A46 Coventry Junctions (Walsgrave) Scheme Number: TR010066

8.16 Applicant's Comments on Submissions Received at Deadline 1

**APPLICANT'S COMMENTS ON SUBMISSIONS
RECEIVED AT DEADLINE 1**

Rule Number	Rule 17(1)
Planning Inspectorate Scheme Reference	TR010066
Application Document Reference	TR010066/EXAM/8.16
Author	A46 Coventry Junctions (Walsgrave) Project Team, National Highways

#### **Figure 2.4 Environmental Masterplan**

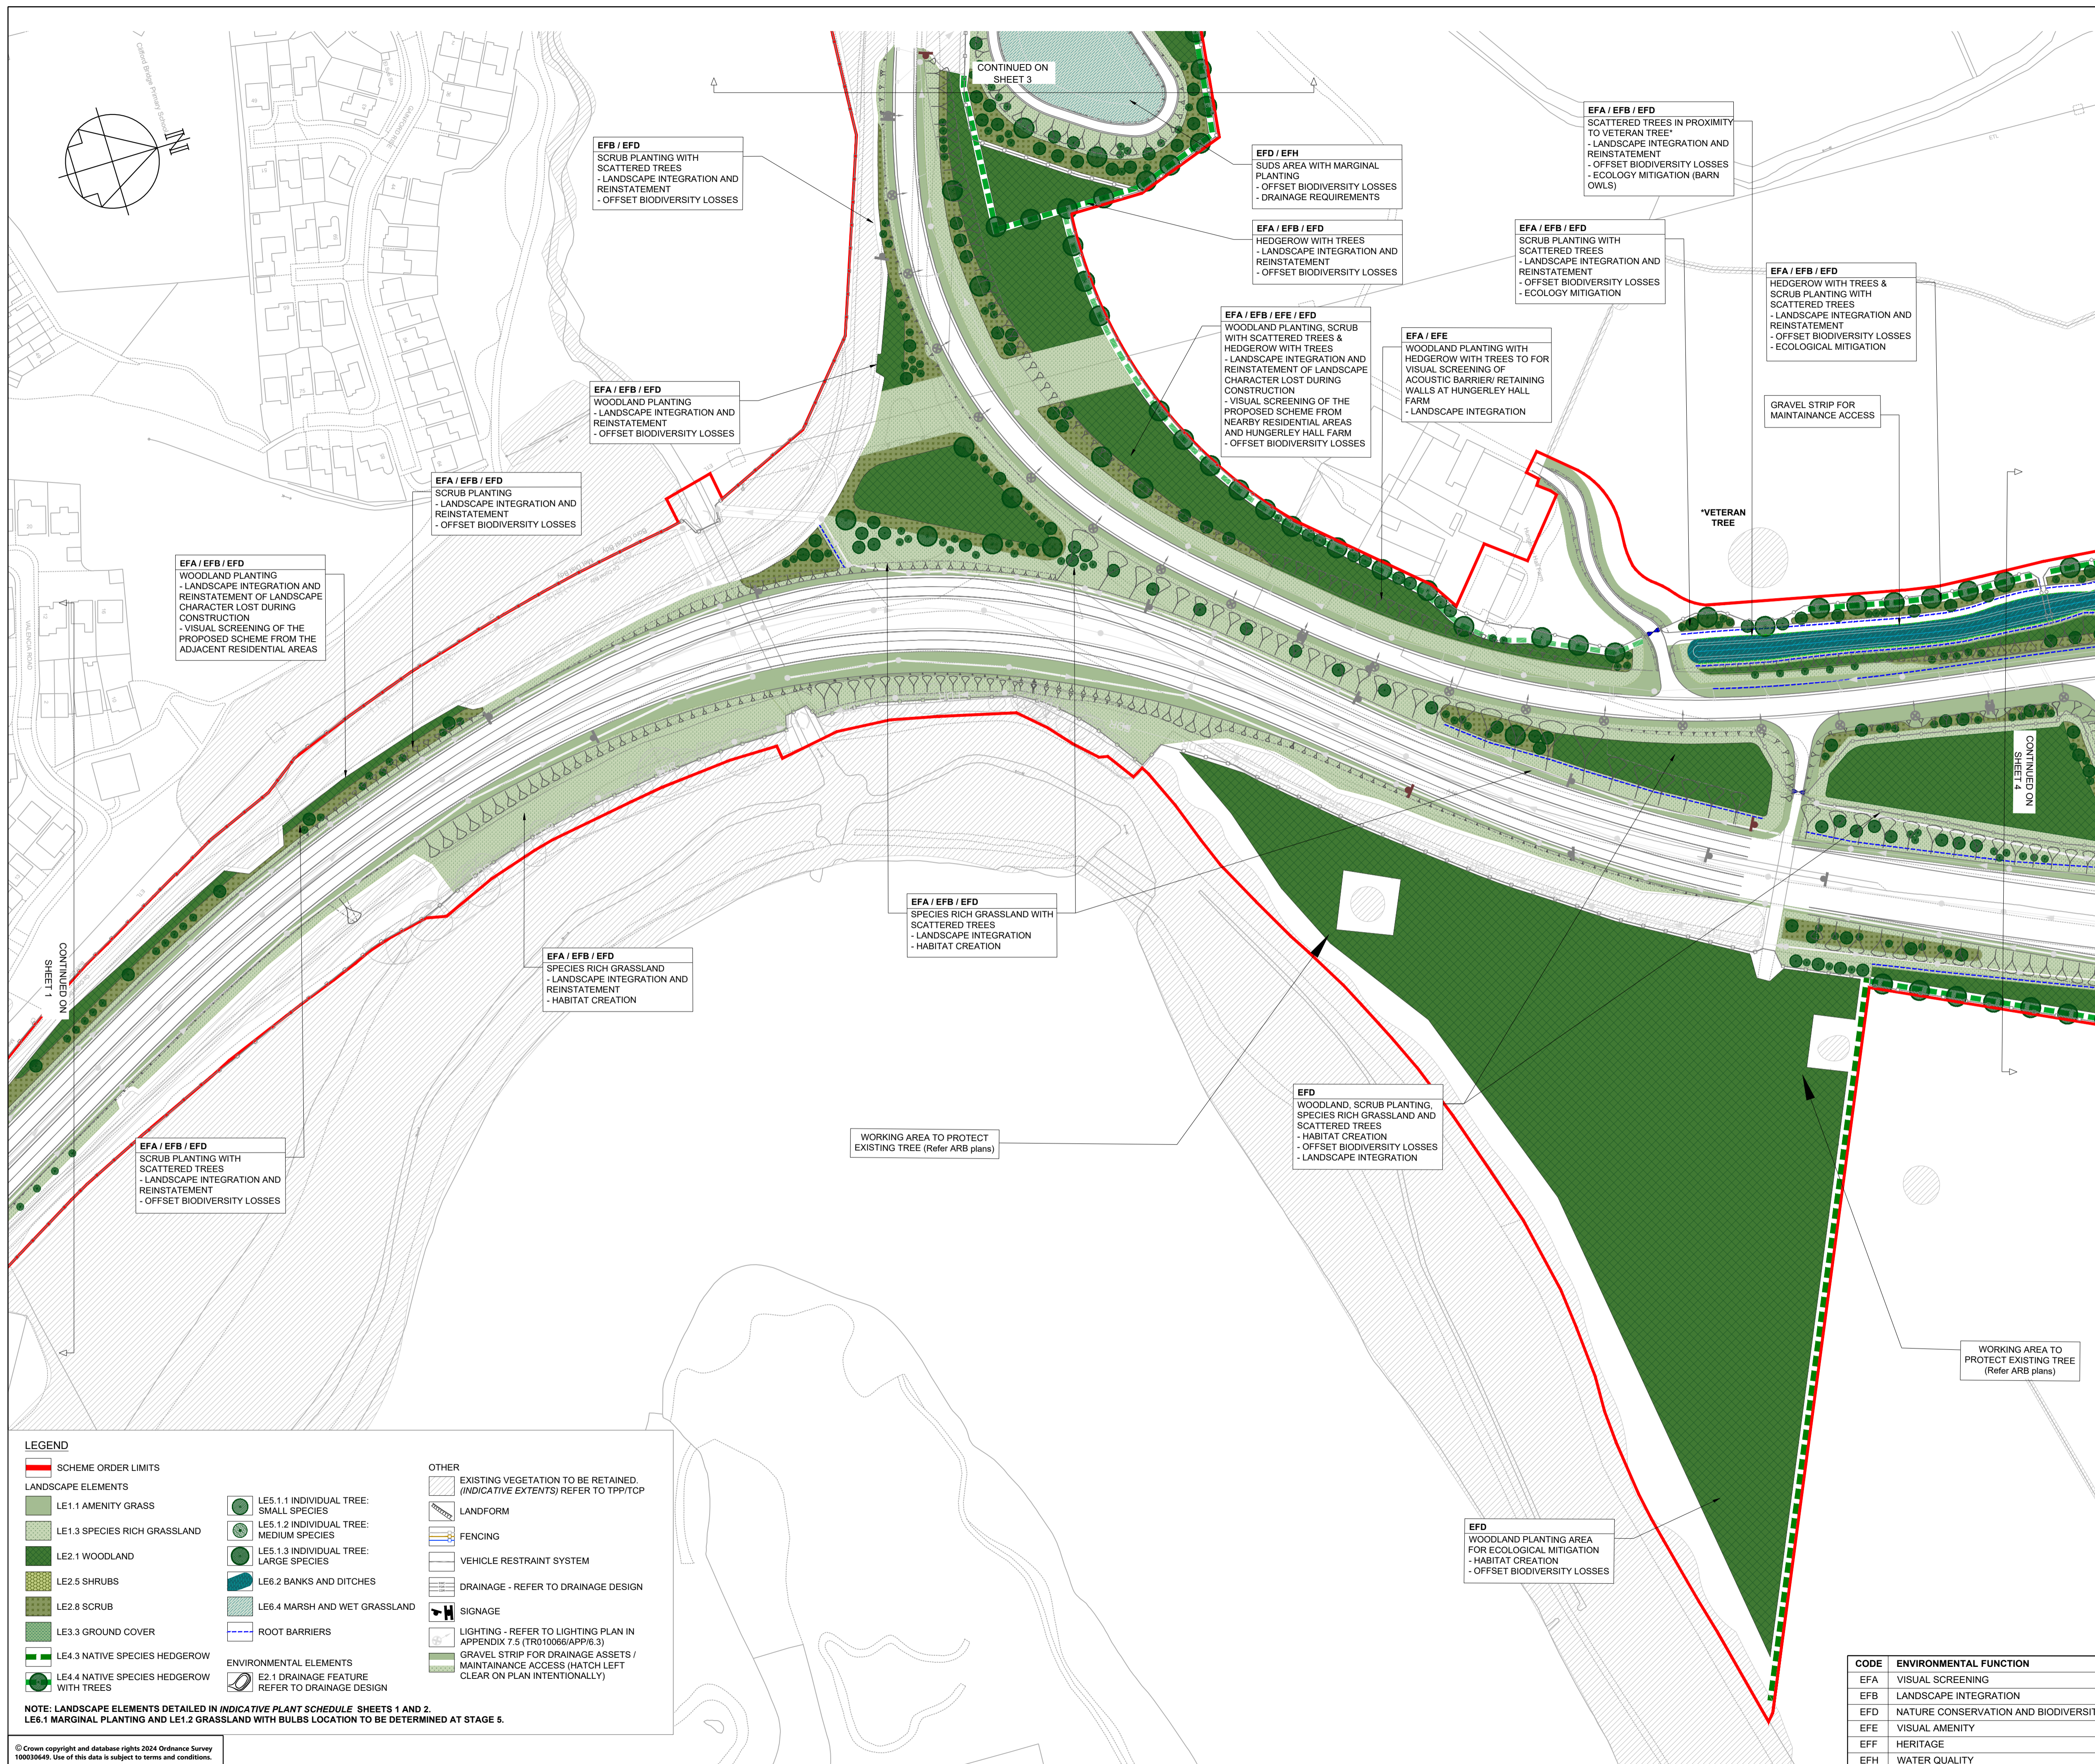
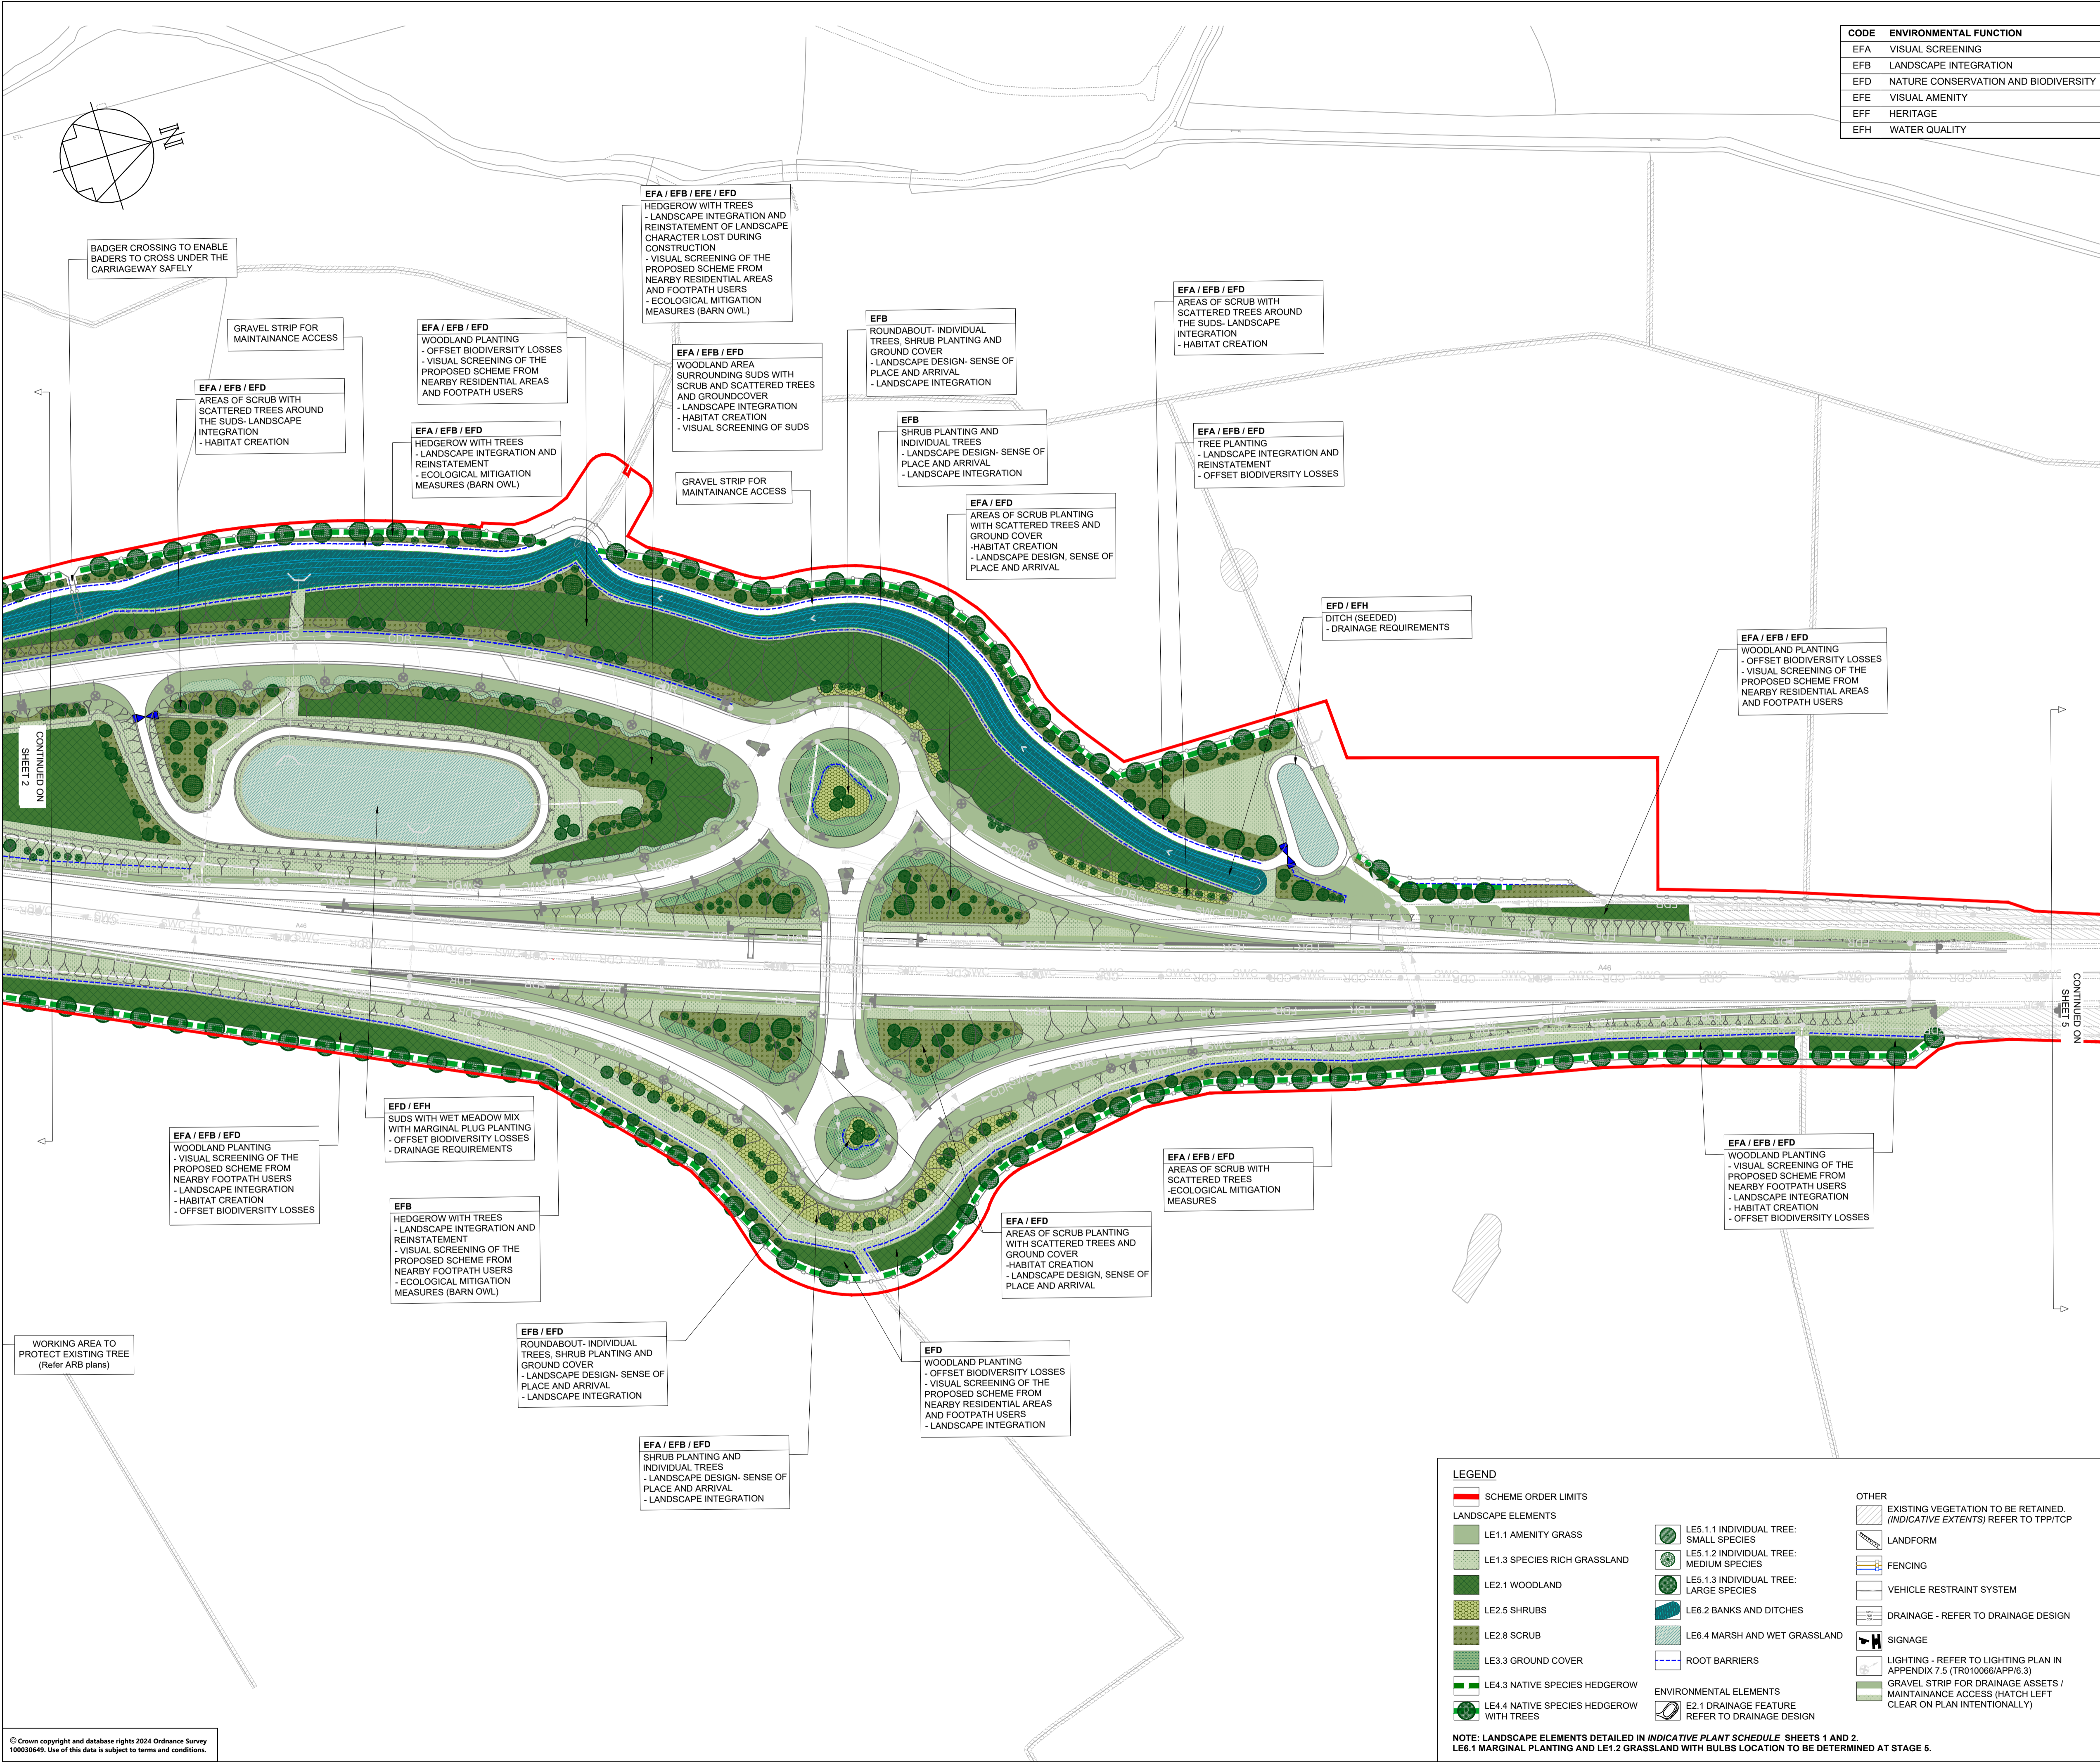
AP10 bullet 2	<p><i>Action - What is the Environment Agency's position on the Applicant's proposals to protect and enhance watercourses and the development of new habitats in proposed detention basin?</i></p> <p>The Environment Agency (EA) approves of the proposed measures outlined in Figure 2.4, to plant scrub, hedgerows and woodland around the new detention basin, to improve connectivity between the waterbody and the surrounding landscape. We also approve of the native seed and plug mixes chosen to enhance the basin (LE6.4, page 12) and to enhance the riparian edges of the watercourses (LE6.2, page 12). However, we would also recommend adding rushes (e.g. <i>Juncus</i> sp.) to the species lists.</p> <p>In addition, further enhancements measures could be considered to make the detention basin and watercourses more attractive to wildlife by providing habitat variety if possible and practicable.</p>	<p>The Applicant will consider the Environment Agency's recommendation to include rushes (e.g., <i>Juncus</i> sp.) in the species lists LE6.2 and LE6.4. This will be done in collaboration with the Scheme ecologists and drainage experts to determine their practicable inclusion. Additionally, the Applicant will explore further enhancements to the detention basin and watercourses during the detailed design stage, continuing to work closely with the Environment Agency to assess what is feasible and practical.</p>
